Our Ref: 2026/101783

Council Comments - SSD-73688210 - Queenwood School Sporting Facilities - 1100 Oxford Falls Road, Oxford Falls.

Appendix 1 Northern Beaches Council Submission - Detailed Supplementary Comments - SSD-73688210 - Queenwood School Sporting Facilities - 1100 Oxford Falls Road, Oxford Falls

1 ISOMETRIC - HEIGHT PLANE DIAGRAM - WEST

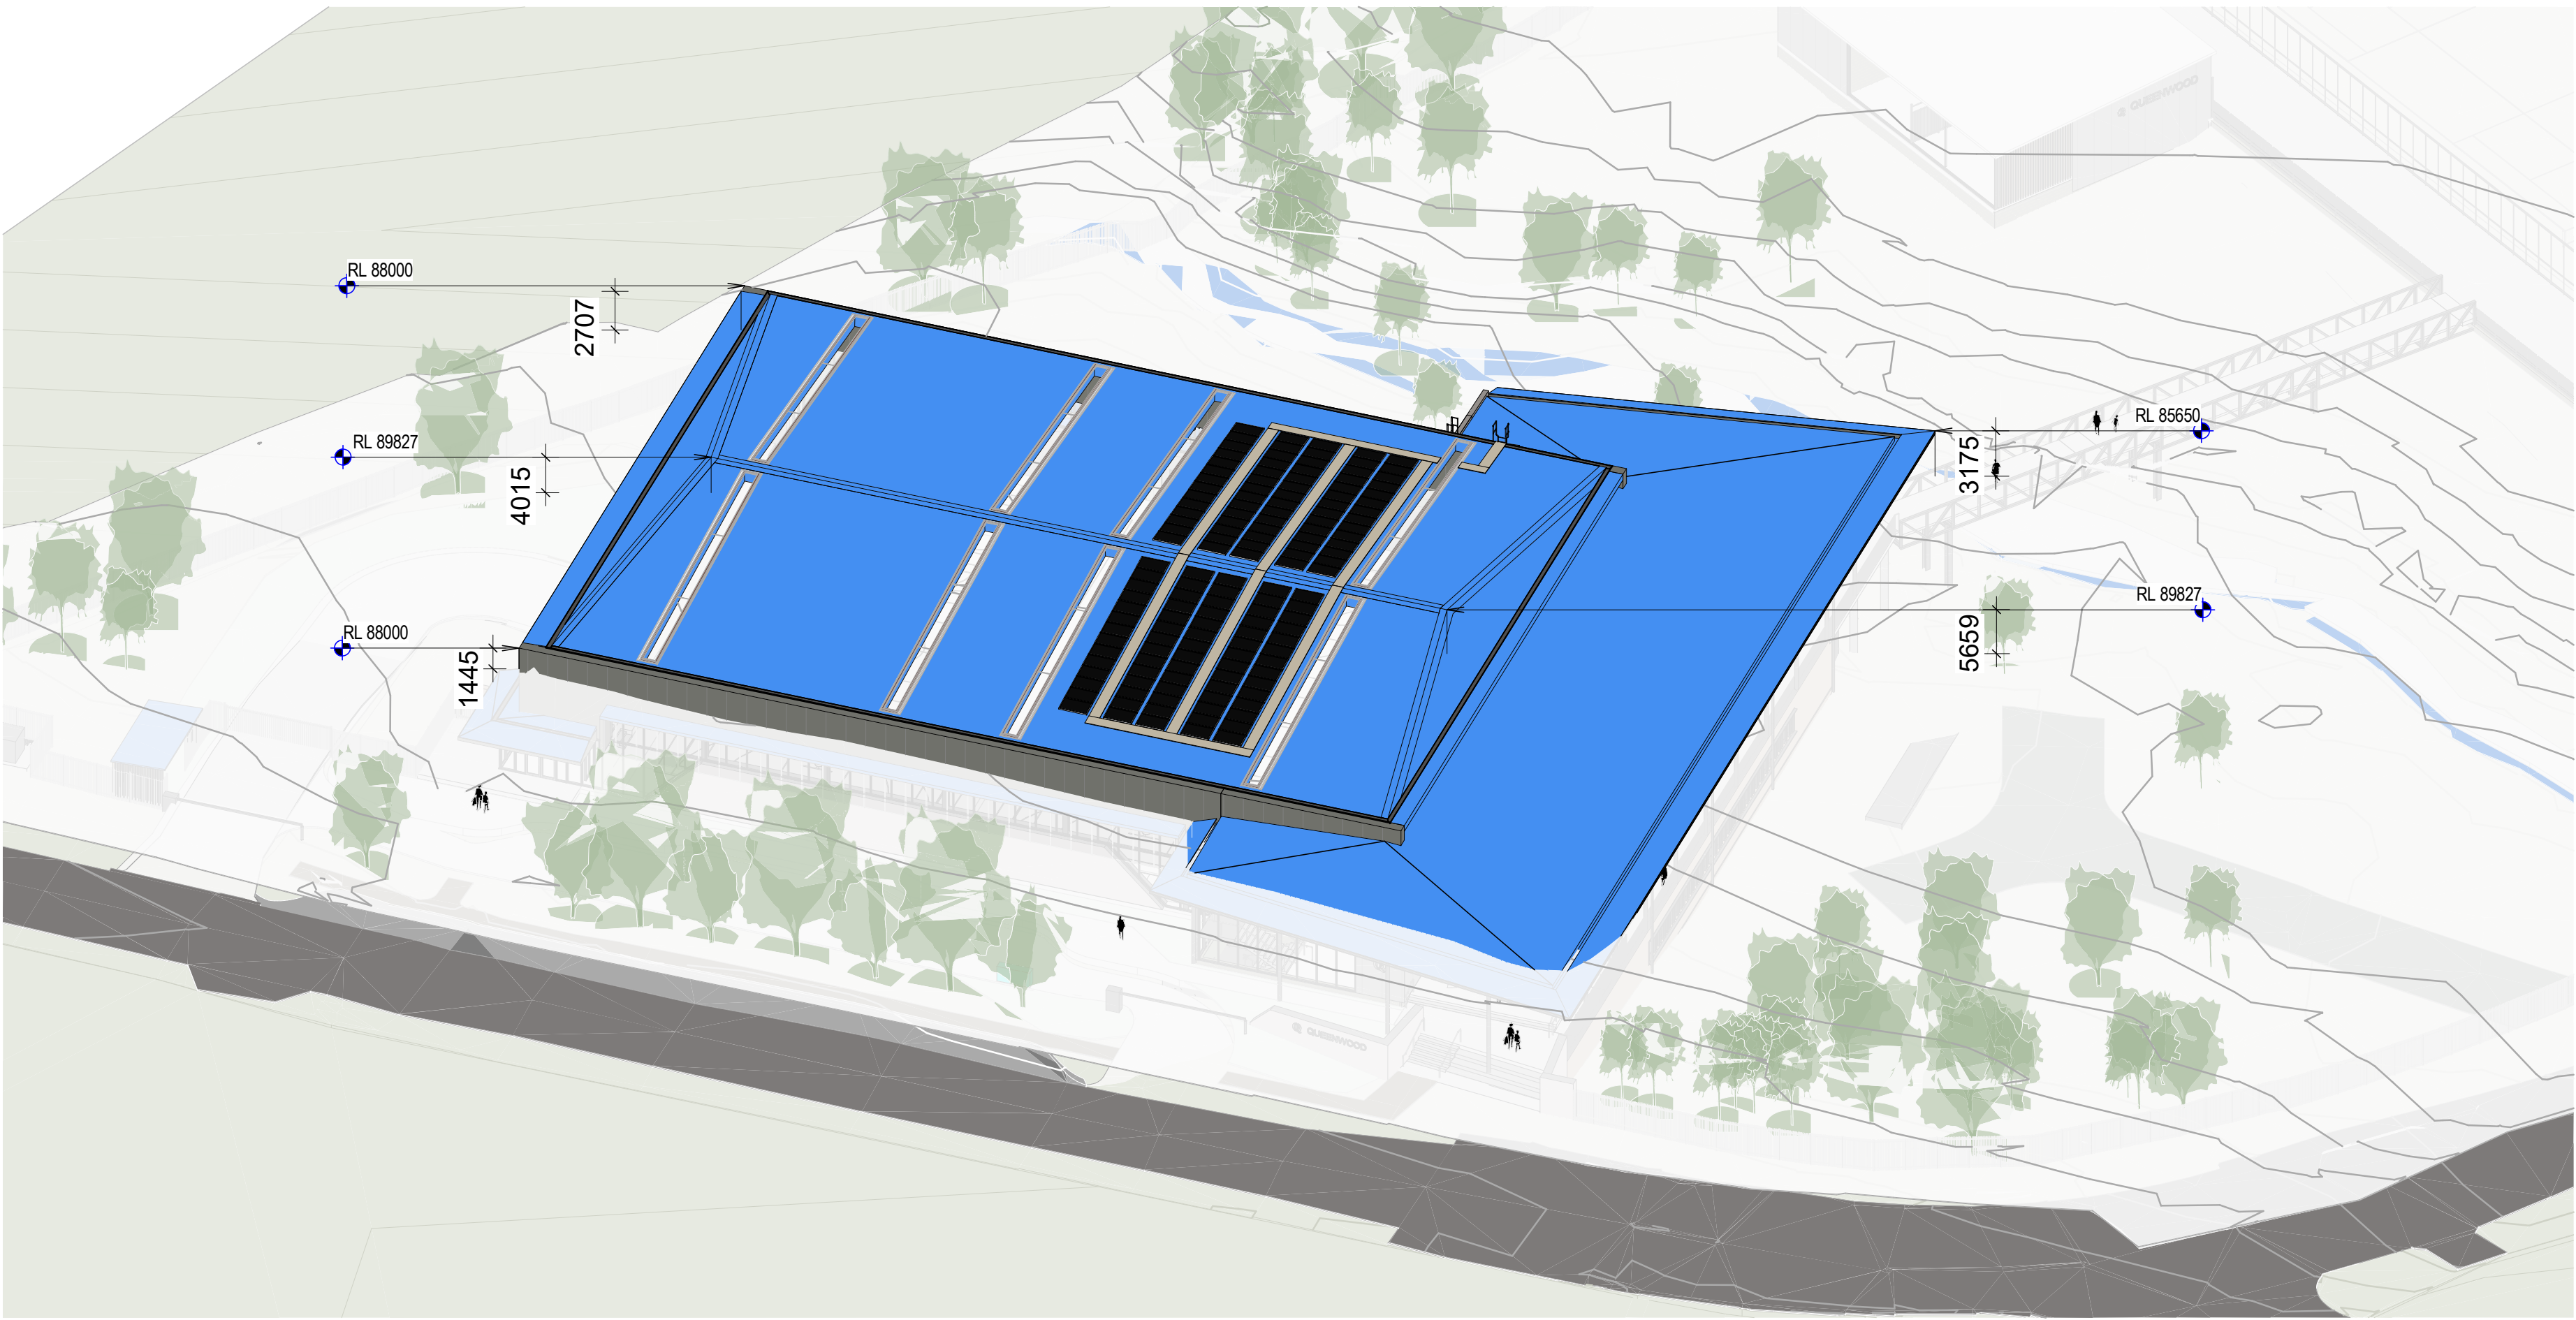
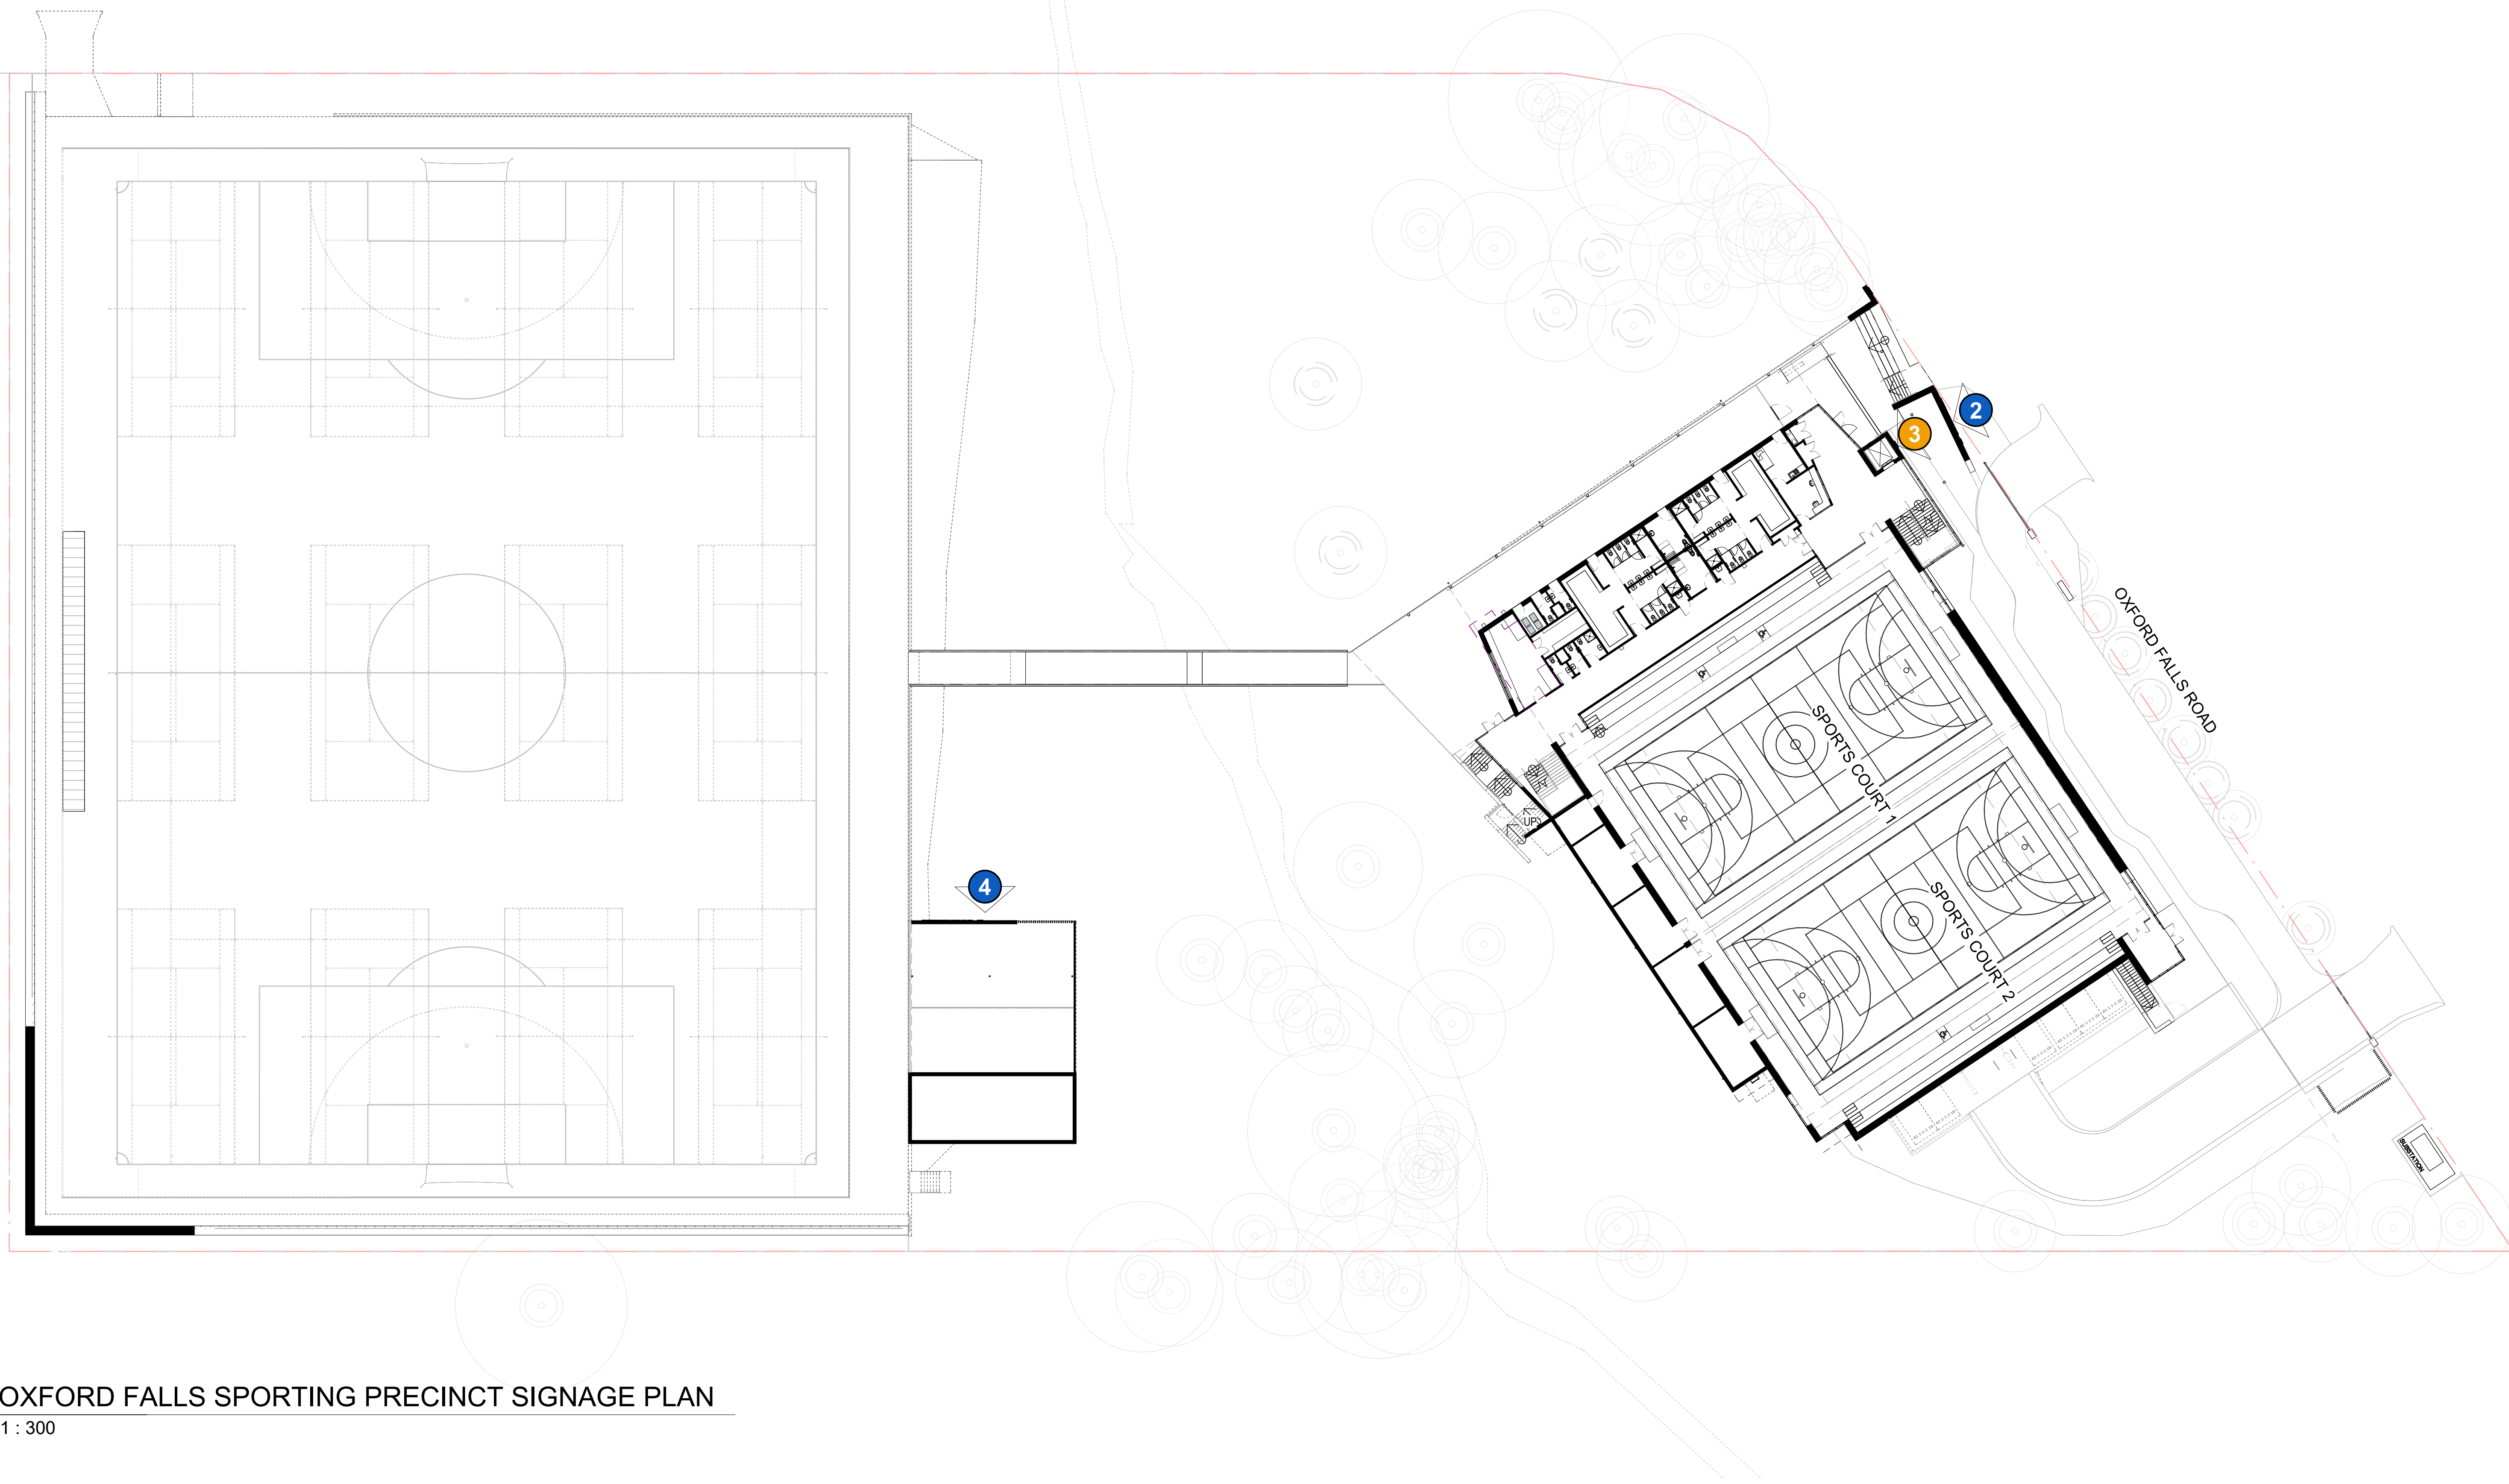
The height being in the vicinity of a storey above the requirement under the LEP (8.5m) also contributes to this visual impact.
